**MECKLENBURG COUNTY**  
**Land Use & Environmental Services Agency**

**MEMORANDUM**

To: Charlotte-Mecklenburg Planning Commission  
From: LUESA, Mecklenburg County  
Date: 2.24.22  
Subject: Rezoning Petition Comments

**2021-221: The Kid's Workshop**

N
 1 ENLARGED SITE PLAN
 RZ-2.0 1/16" = 1'-0"

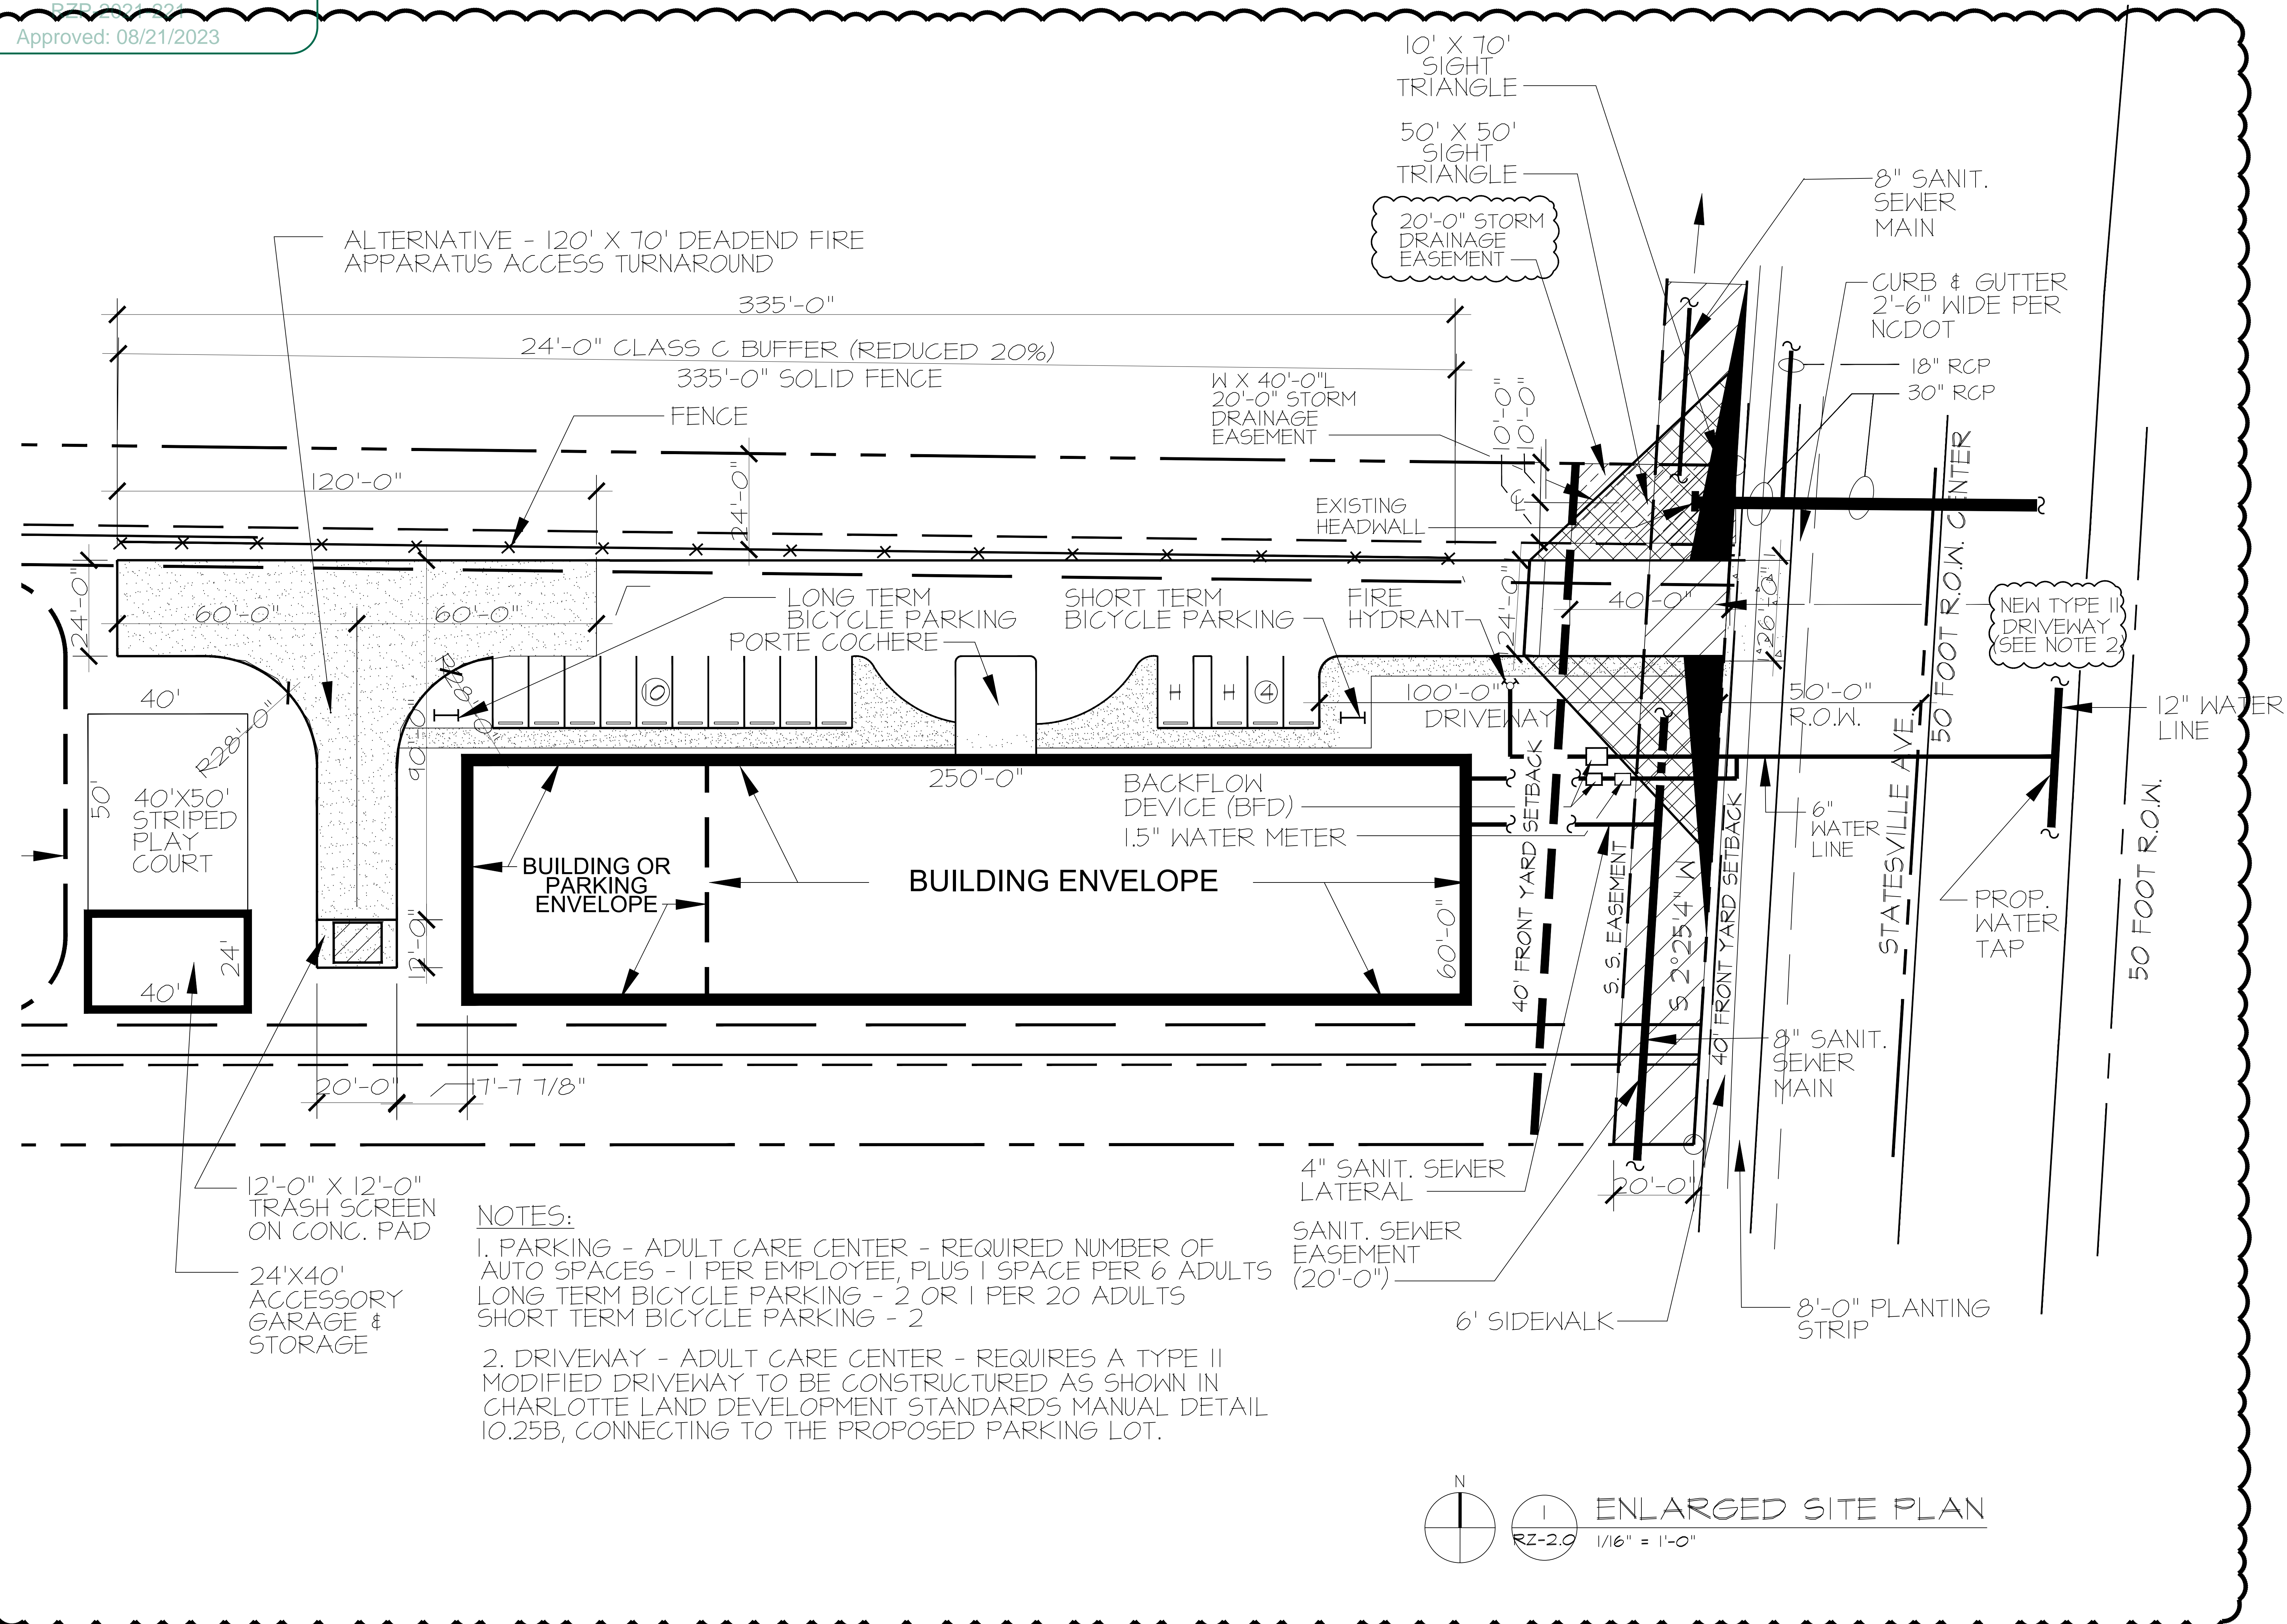
The proposed development is planned to serve a multifamily/community/office group and to have vehicle parking greater than or equal to 20 spaces. Mecklenburg County Air Quality recommends that the proposed development be constructed with at least 10% EV-ready parking spaces. EV-ready spaces are those that have pre-installed electrical panel capacity with a dedicated circuit, raceway with conduit, and either a junction box or 240V outlet.
